Memorandum

From: Jim Strozier, Consensus Planning, Inc.

Date: July 19, 2023

Re: *PR-2022-007063, SI-2023-01044 DFT PV Trails/La Terra – DFT Comments and Responses*

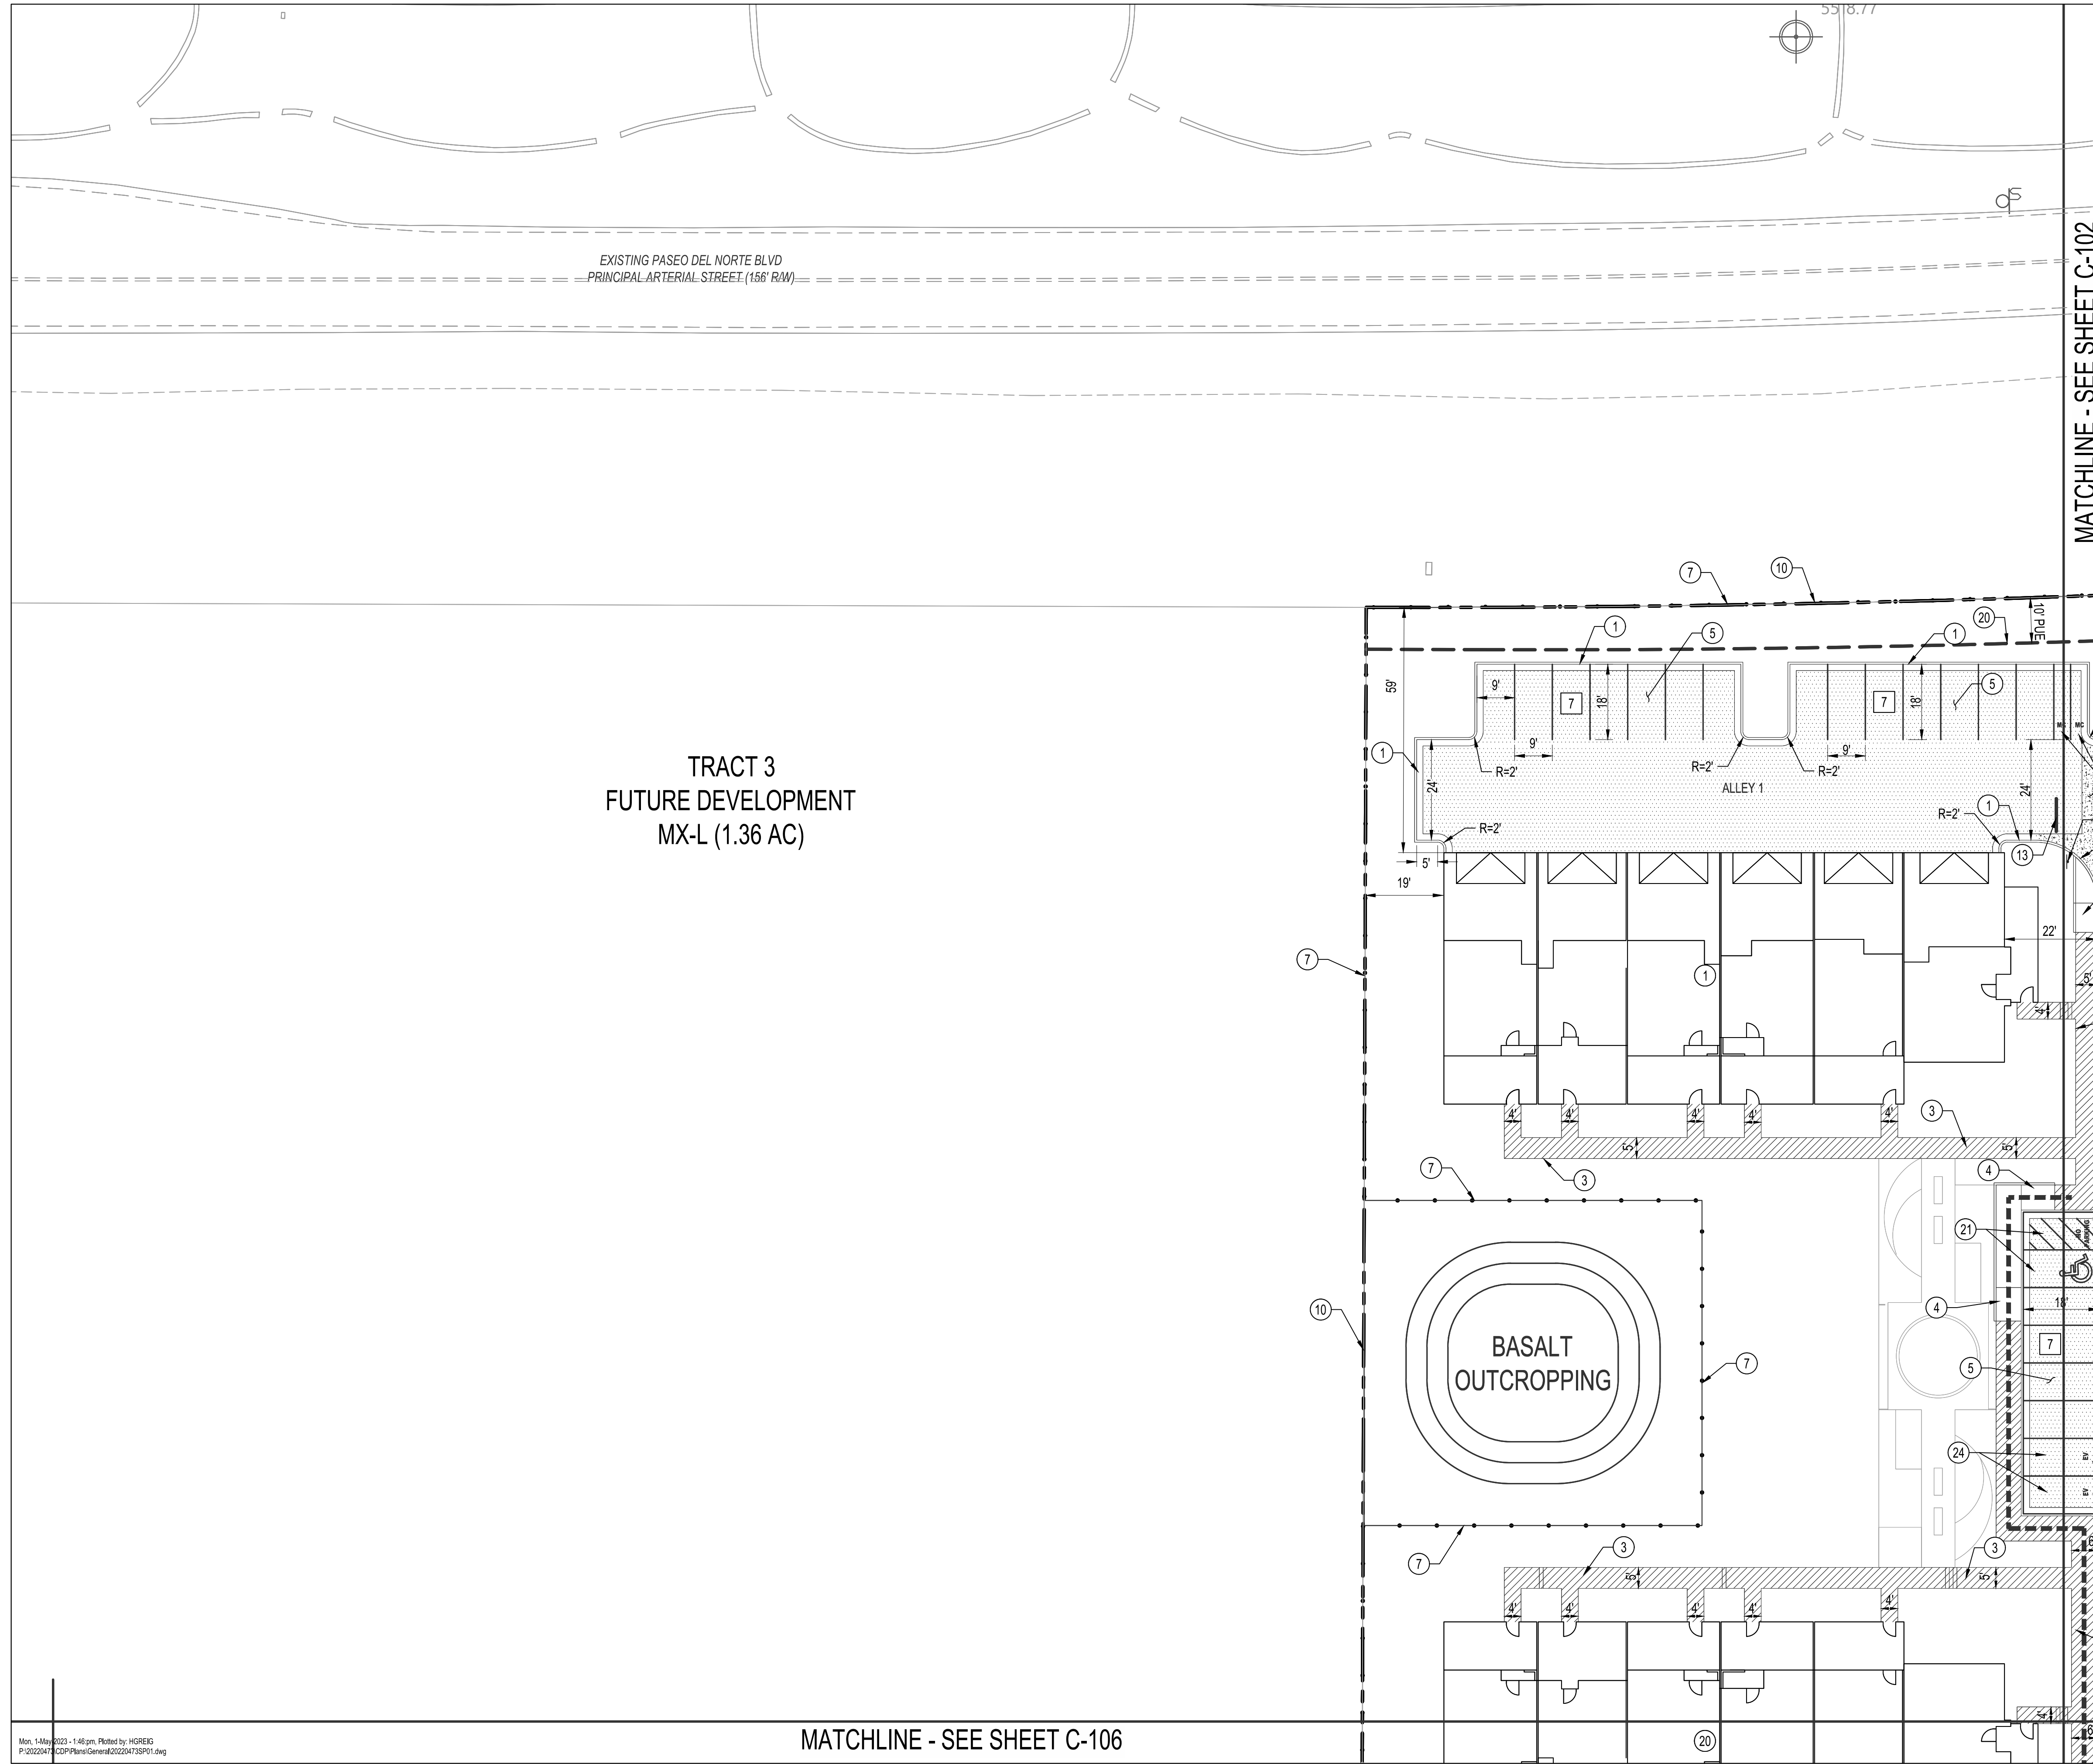
2. Site Utility Plan

- a. Call out appropriate easements along named streets. i. Easement shall be provided such that Tract 3 has access to the 8" WL along Street 1.

- b. Label all private infrastructure "Private" and provide a clear delineation.

- c. Label all Public infrastructure "Public" and provide a clear delineation.

Applicant Response: *Easement has been updated to provide access to Tract 3.*

Applicant Response: *Exhibit has been updated to reflect this.*

Applicant Response: *Exhibit has been updated to reflect this.*
